EL PASO COUNTY

DEPARTMENT OF PARKS AND COMMUNITY SERVICES

April 4, 2024

Subject: Stonebridge Metropolitan District Nos. 1-6 Review (ID-24-001)

1. Vicinity Map
2. Initially Included Property Map
3. Proposed Infrastructure and Amenities Maps
 - i. Detention, water and wastewater infrastructure, roadways, parks, and open space
4. Legal Descriptions of Initially Included Property

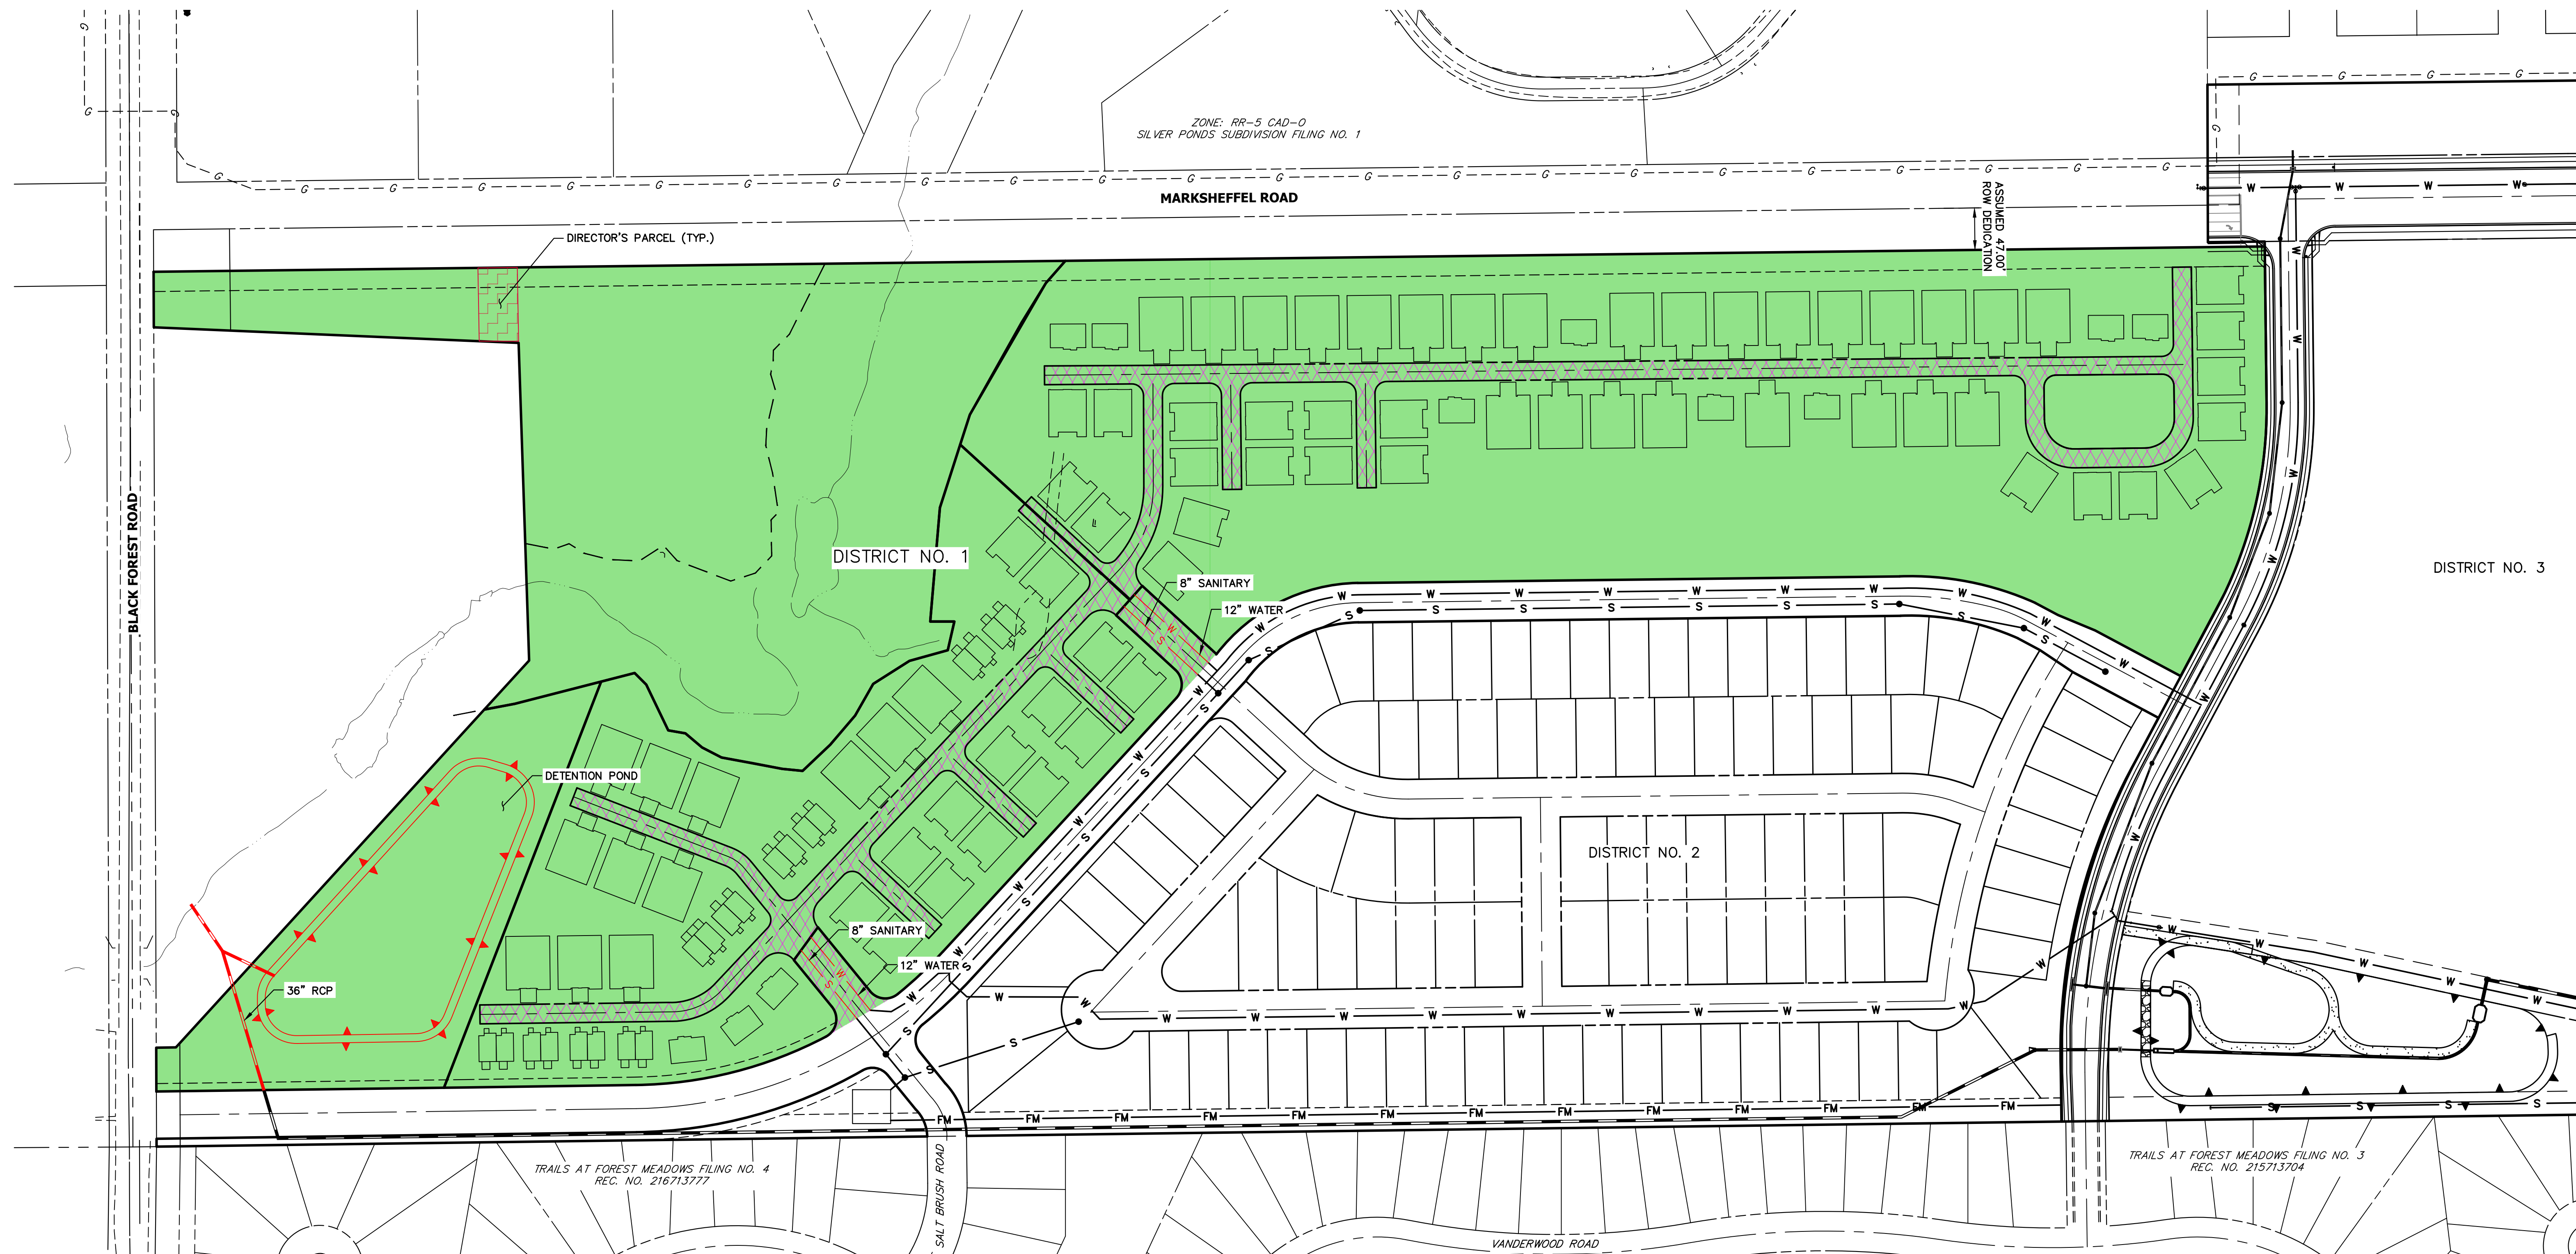
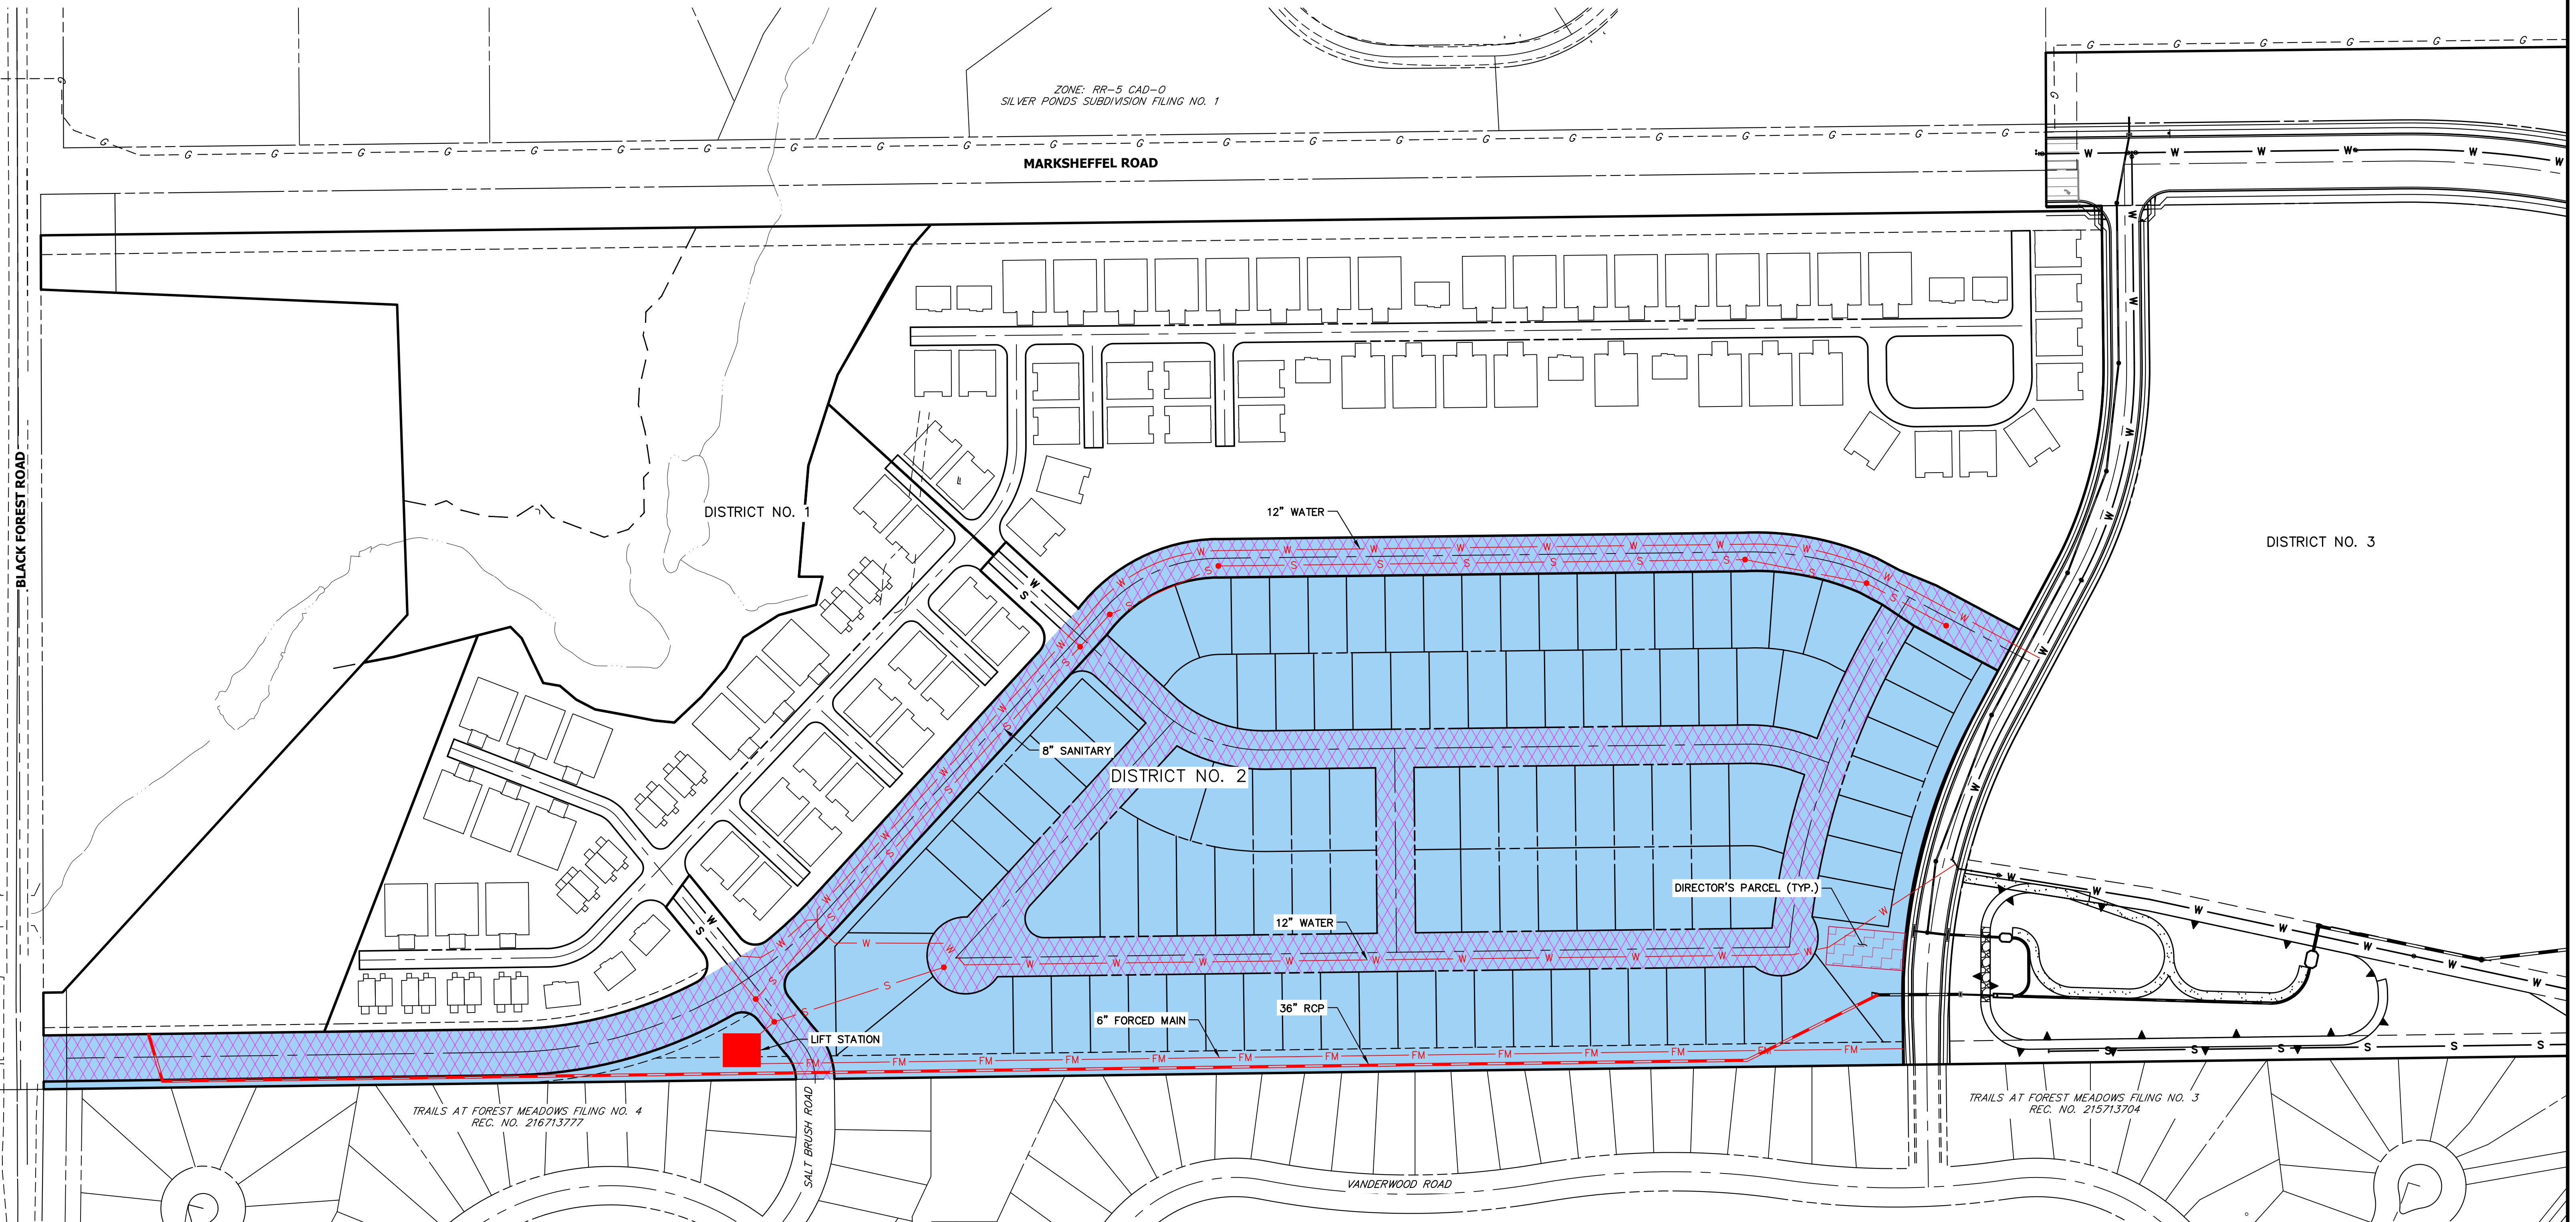
The applicant's Letter of Intent and proposed Service Plan make mention of future parks, trails, and open space, but these recreational facilities are not shown on the submitted Service Area maps. The Stonebridge Metropolitan District Service Plan and Letter of Intent do include the following statements in regard to parks, trails, and open space:

In conclusion, Parks staff is encouraged by the applicant's desire to bring high-quality recreational amenities to the residents and visitors of the Stonebridge community. However, staff recommends that the applicant include generalized plans, descriptions, and locations of these recreational facilities in either the Letter of Intent or included in the Service Area maps, as with other planned improvements, such as roadways, sewer and water deliver systems, and stormwater detention facilities.
